**CITY OF ALBUQUERQUE
PLANNING DEPARTMENT
August 31, 2016
DRB Comments**

PROJECT # 1010975 APPLICATION # 16-70311

RE: Tract 194A & 194B, MRGCD Map #31

Project# 1010975
16DRB-70311 MINOR - PRELIMINARY/
FINAL PLAT APPROVAL

PLAT OF
 Lots A & B
 LANDS OF ALAN M. & MICHELLE E. VARELA
 within the Town of Albuquerque Grant
 projected Section 31, T.11N., R.3E., N.M.P.M.
 City of Albuquerque, Bernalillo County, New Mexico
 August 2016

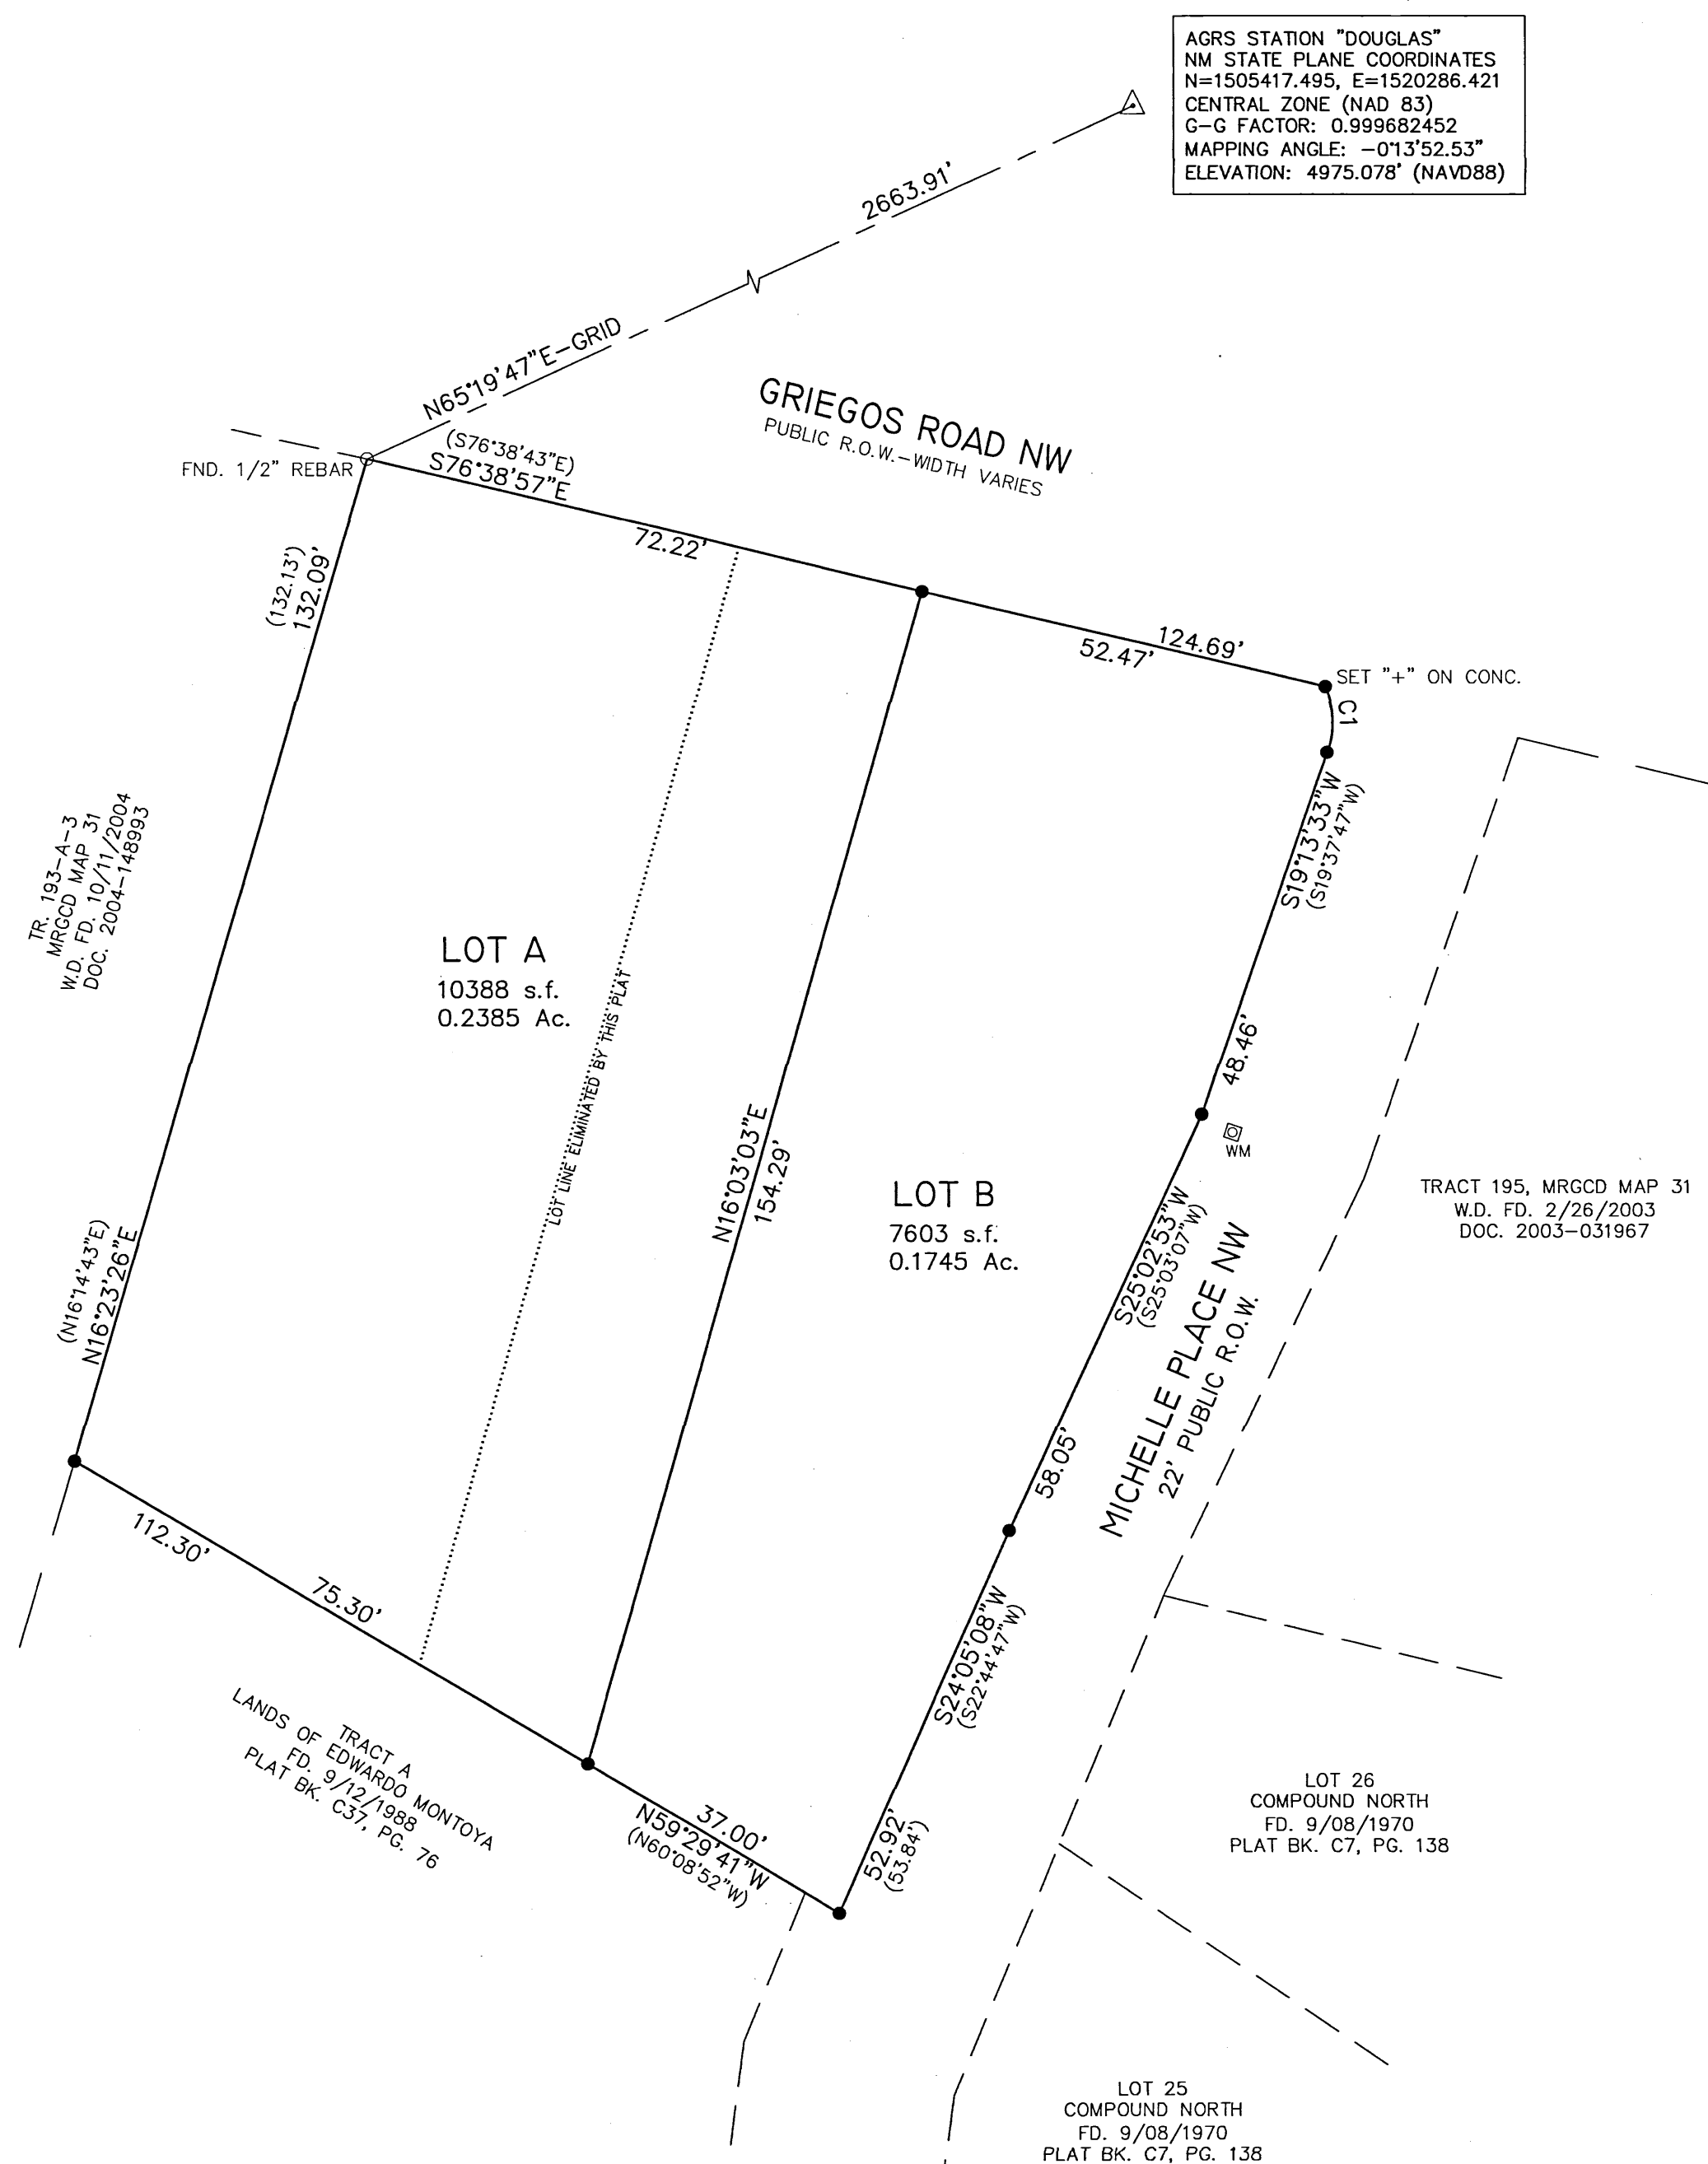
Proposed Lot B would be reduced from the minimum lot area criteria of the Zoning Code for the RA-2 zone a lot size variance would be required.
